***MODIFICATION REQUEST:
Thomas Street Car Park, Chatswood
MP09_0066 MOD 6
Increase in the height of the buildings,
floor space, and car parking including
above ground car parking.***

Director-General's
Environmental Assessment Report
Section 75W of the
Environmental Planning and Assessment Act 1979

July 2013

1 ELEVATION – SOUTH
1:250

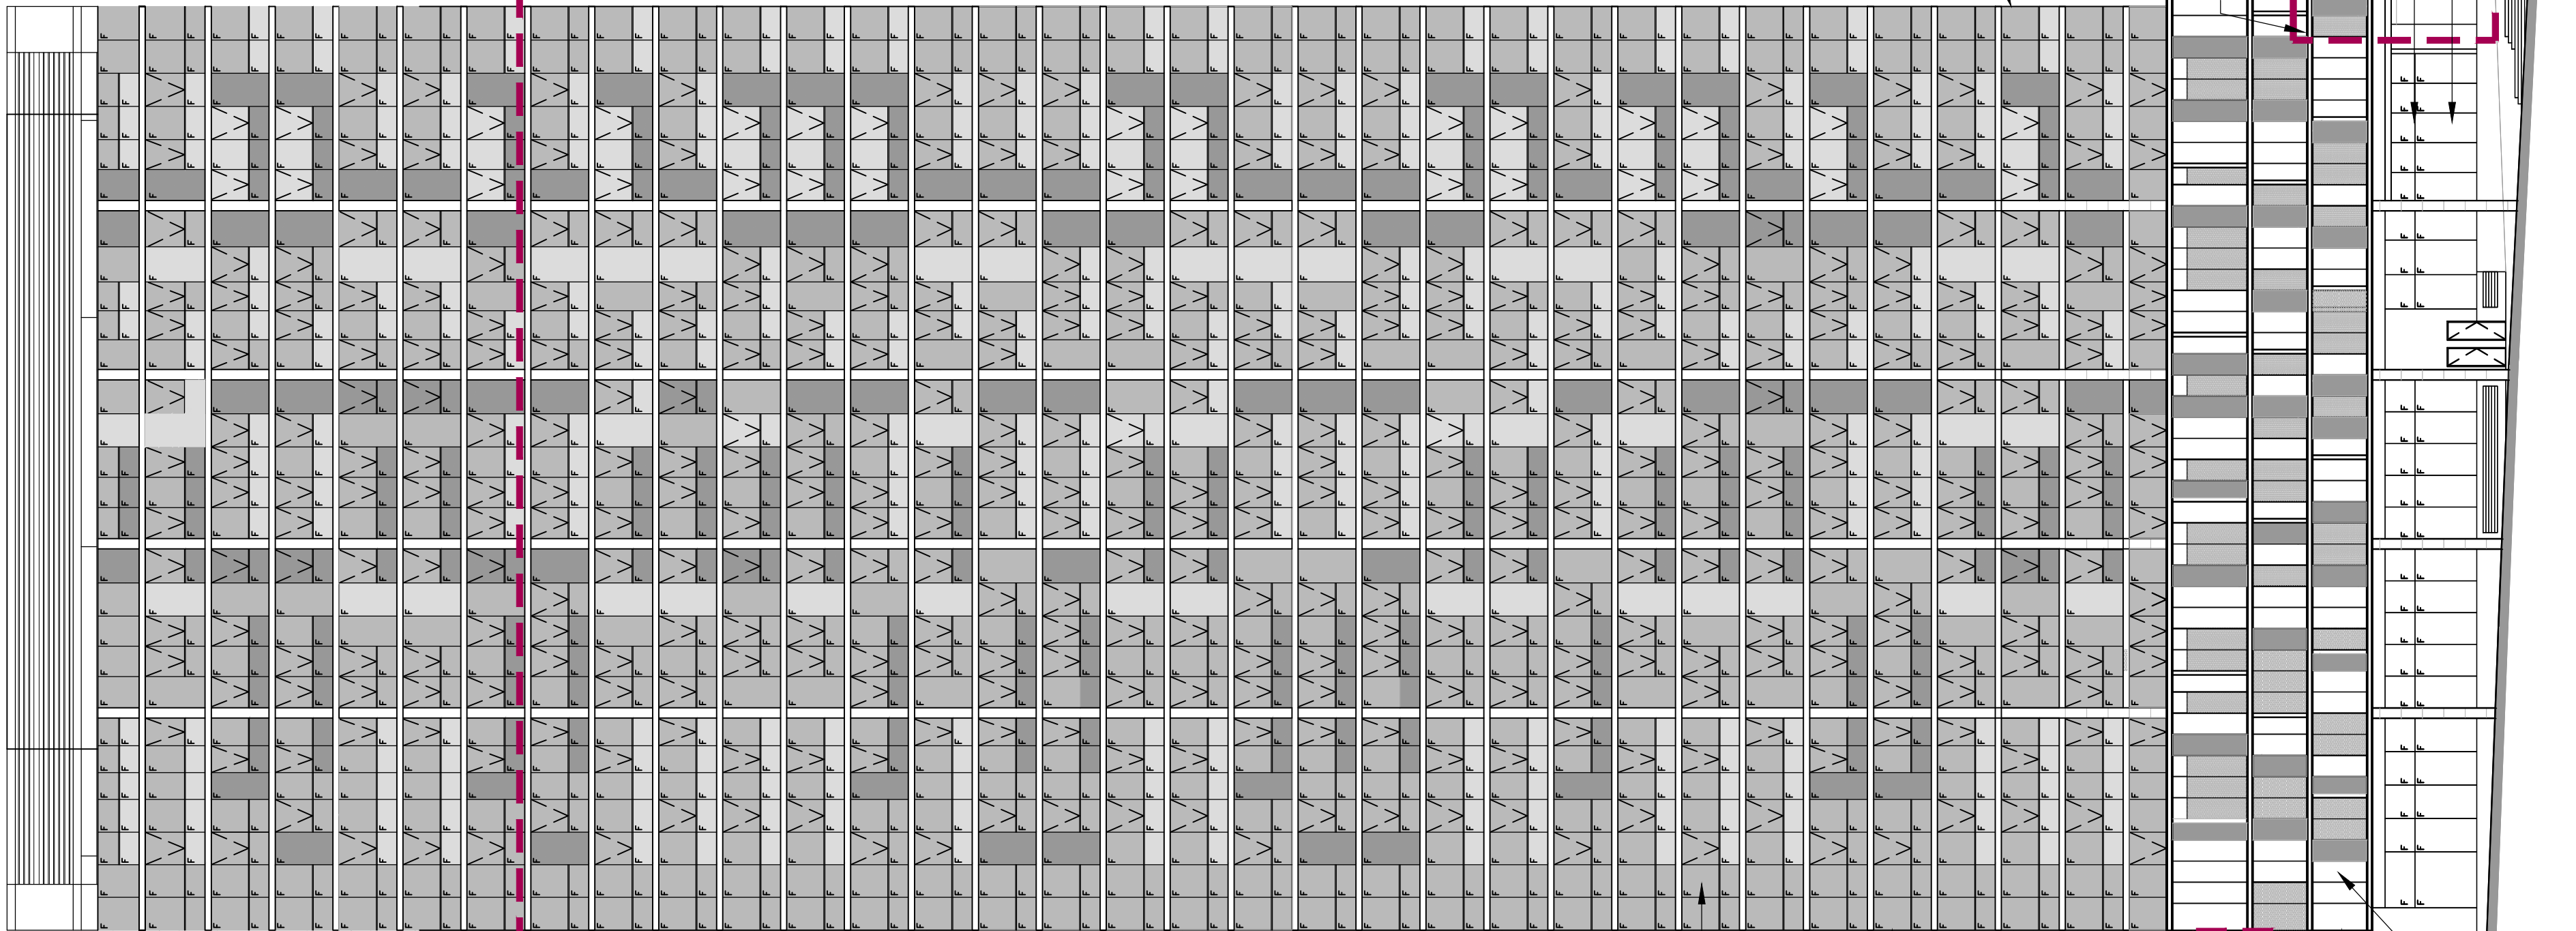
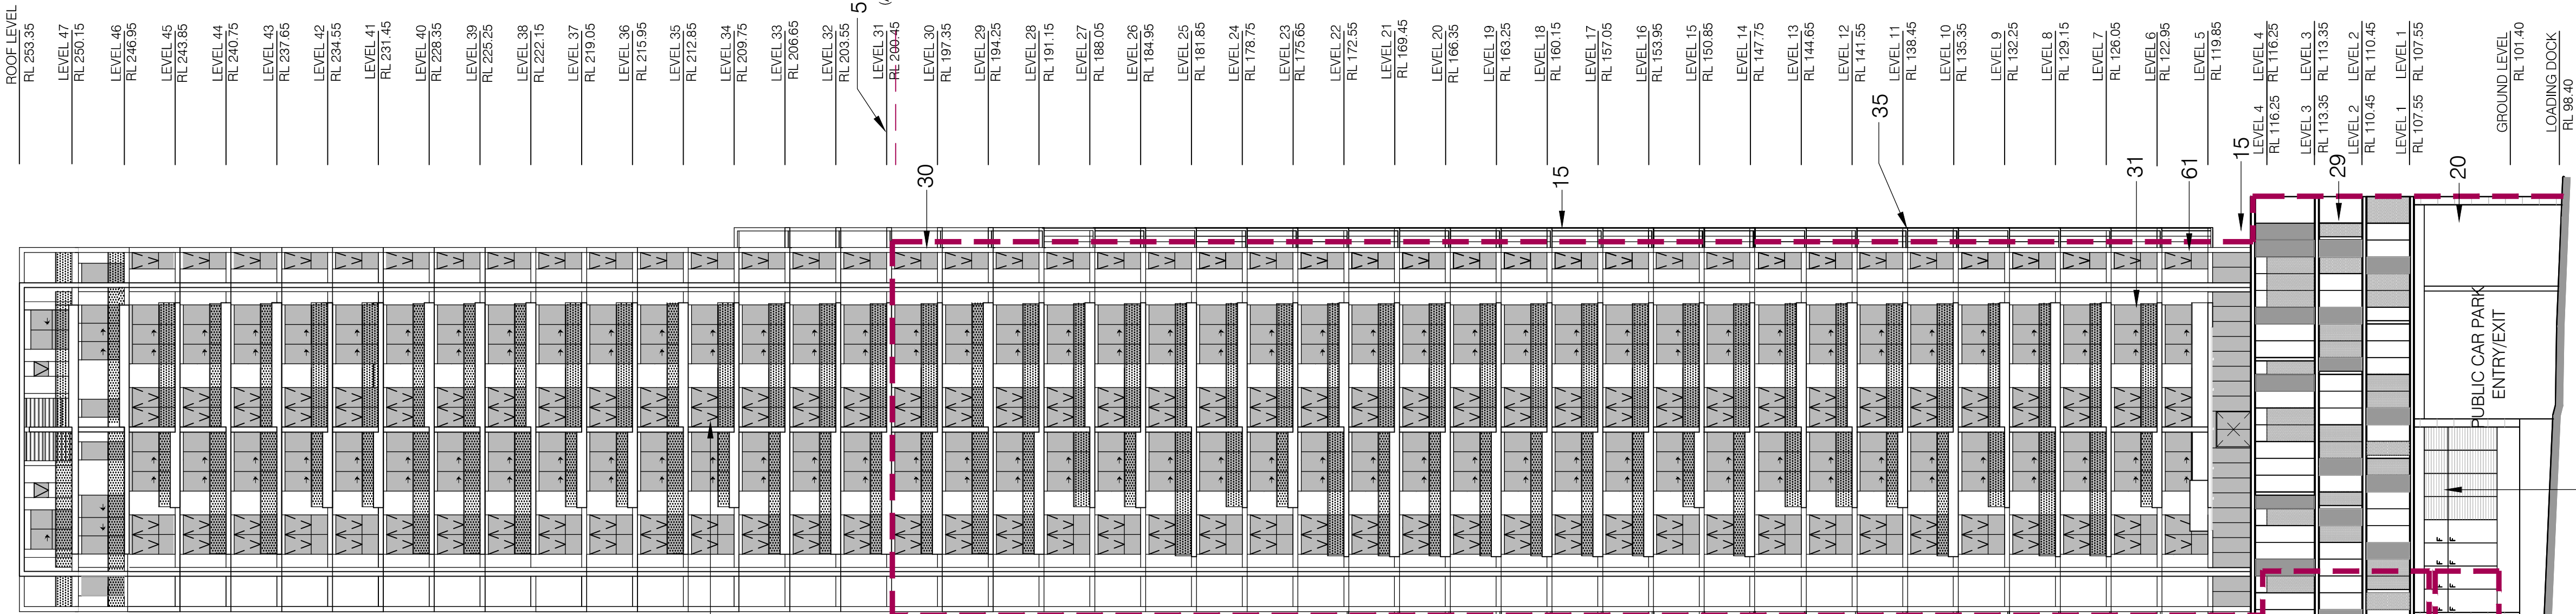
The proposed modification seeks approval for height increases to both towers. The proposed height for Building 1 would be increased by 51.95 metres to RL 253.35 (47 residential storeys plus plant). The proposed height for Building 2 would be increased by 24.75 metres to RL 221.95 (37 residential storeys plus plant).

BUILDING 1
ELEVATION - EAST
A-0123
D
SECTION 75 W MODIFICATION 6

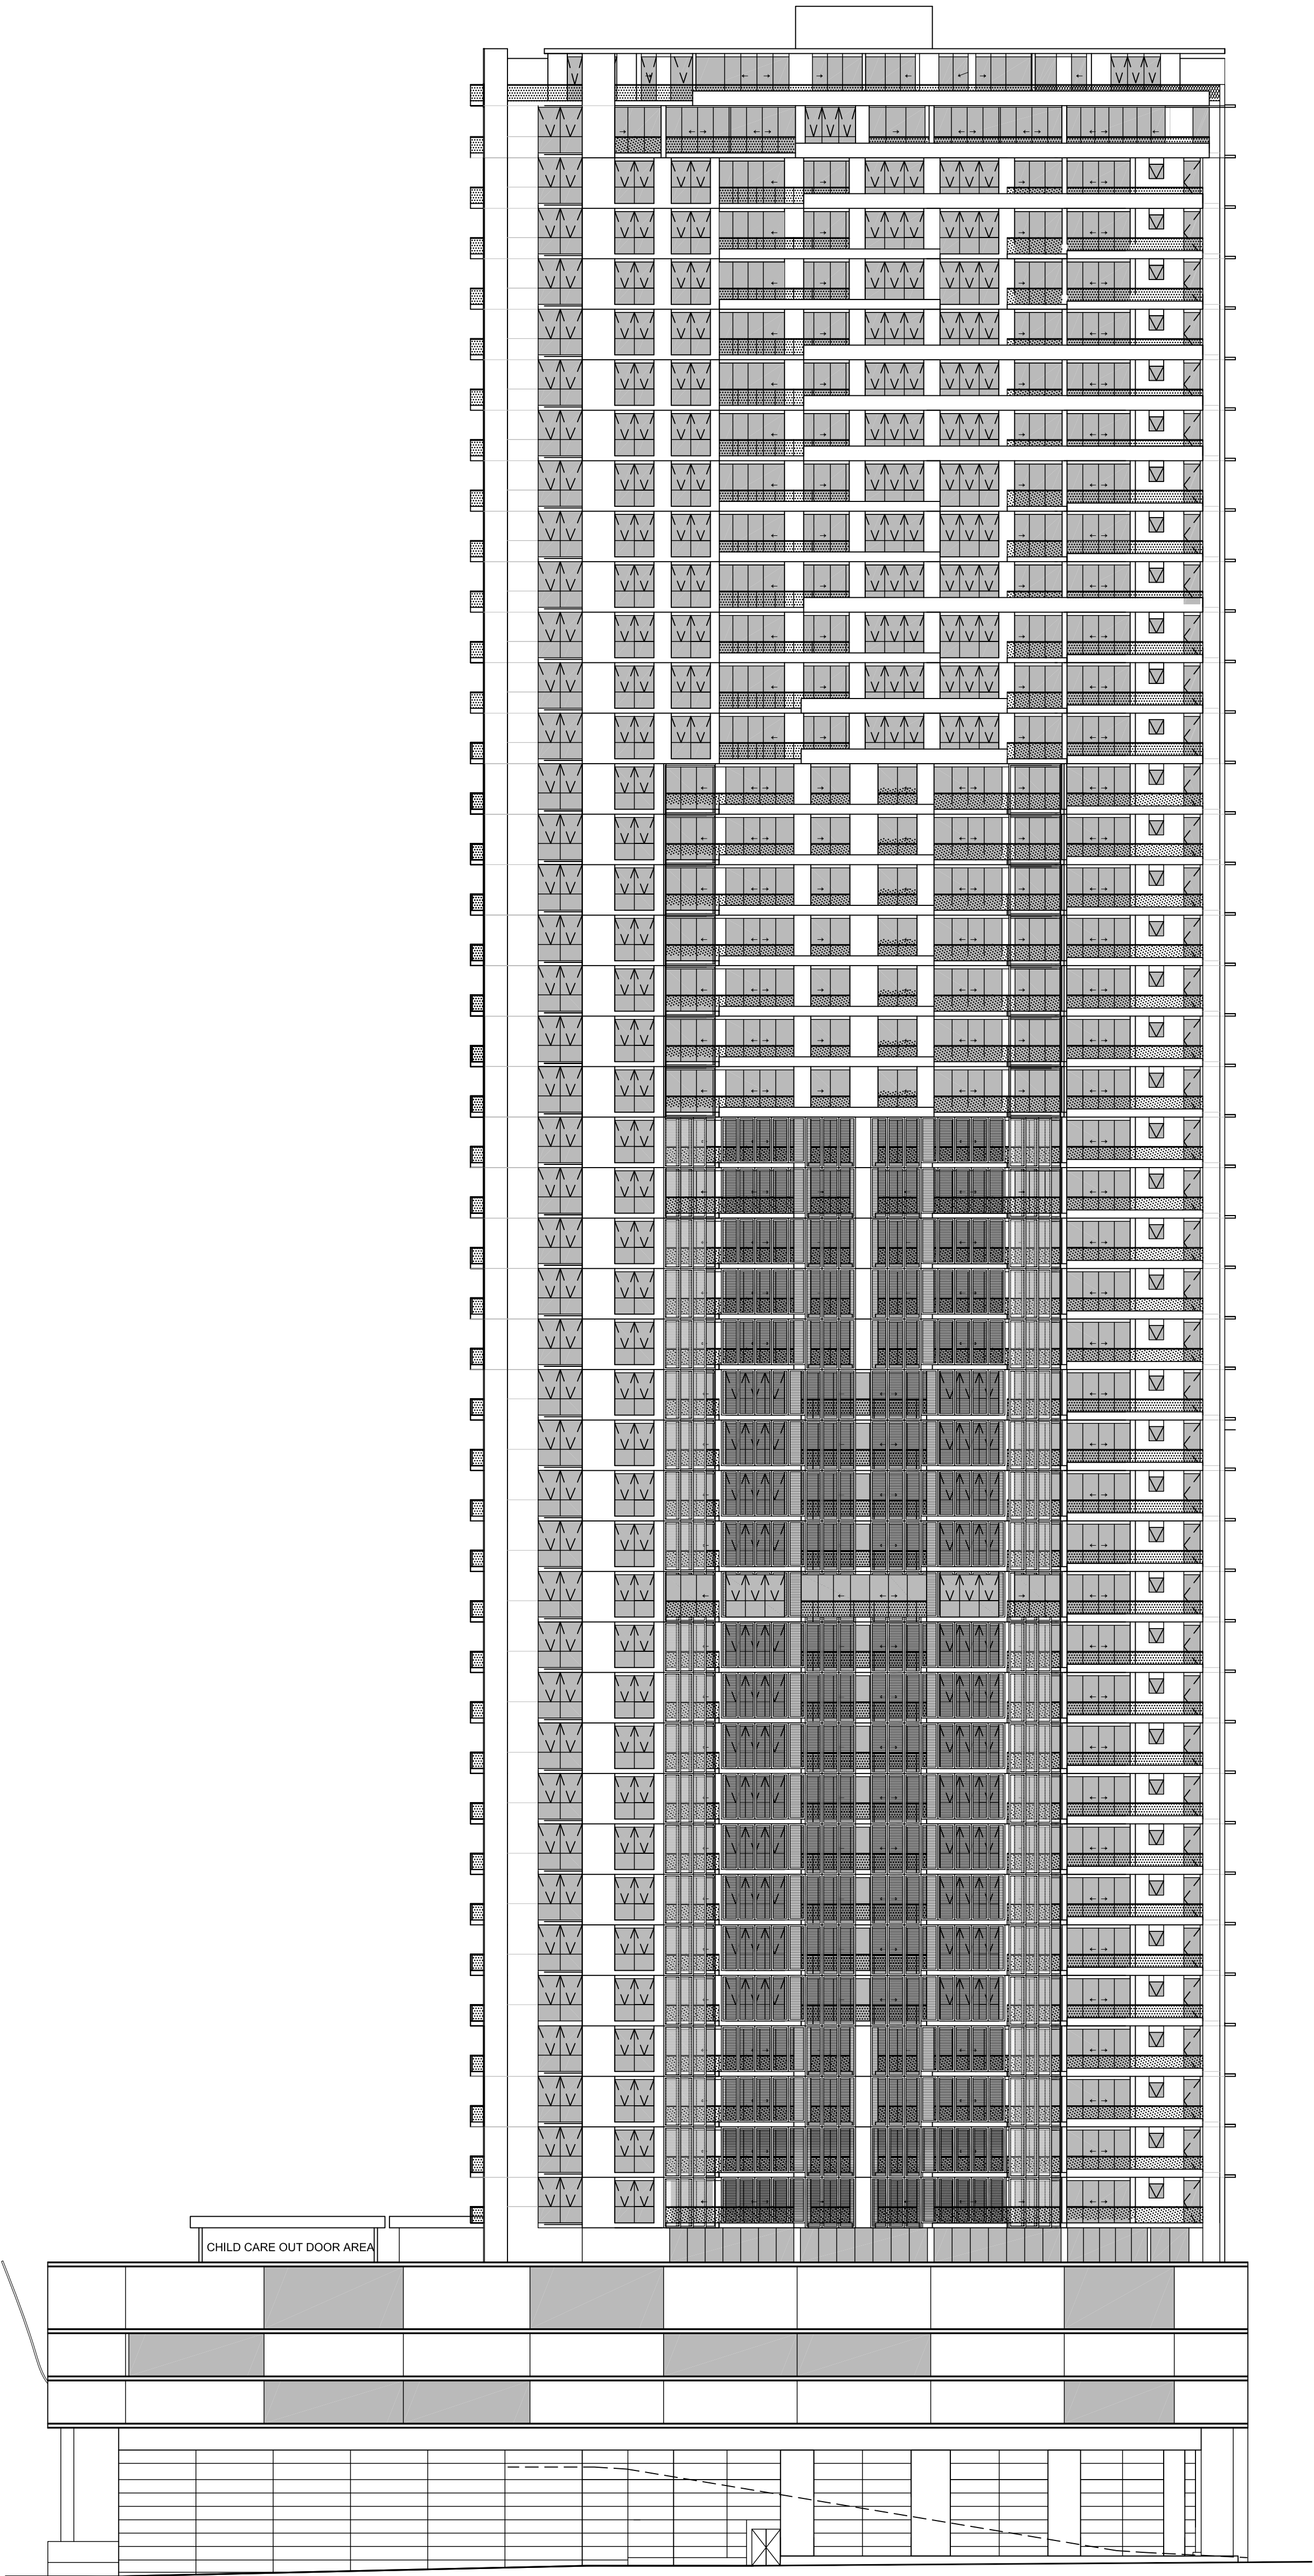
Notwithstanding the above, the Department considers that the proponent's justification for the additional height of 18 storeys for the residential tower, which relies on comparing it to the tallest building in the Chatswood CBD and providing a notional arc to inform building heights, is not robust and overly simplistic.

The proponent's notional arc bears little relationship to the existing skyline (apart from the CTPP Towers) or strategy for future development of the CBD. The application of this arc would infer that it is appropriate to provide taller buildings than the CTPP Towers. The Department does not consider that this is a sound planning approach and does not consider that matching the height of the tallest nearby building achieves an appropriate outcome as it does not achieve a form that emphasises the town centre of Chatswood. In urban design terms, the Department considers that it is more appropriate that the CTPP Tower, which marks the location of the transport interchange and is arguably toward centre of the CBD, should be maintained in the skyline as a higher and more dominant form.

The Department considers that a more supportable approach is to allow the CTPP tower to read as the tallest building in the CBD, and for new towers to step down from this level in order to achieve a better tower height distribution for the CBD skyline. With this approach, the Department considers that a better urban form is achieved by reducing the height of the proposed residential tower to a height midway between the height of the serviced apartment tower and the top floor of the CTPP project. This would result in a reduction of height of Building 1 by approximately five storeys (marked in yellow on **Figure 11**). This will reduce the gross floor area by 3,830m² and the total number of apartments by 40.

Conditions of approval are recommended to achieve a reduction in the height of the proposed residential tower (Building 1) by five storeys. With the imposition of this change, the Department considers that the height of the buildings would be acceptable from an urban design perspective and provide a more appropriate fit when compared to heights of other buildings within the CBD.
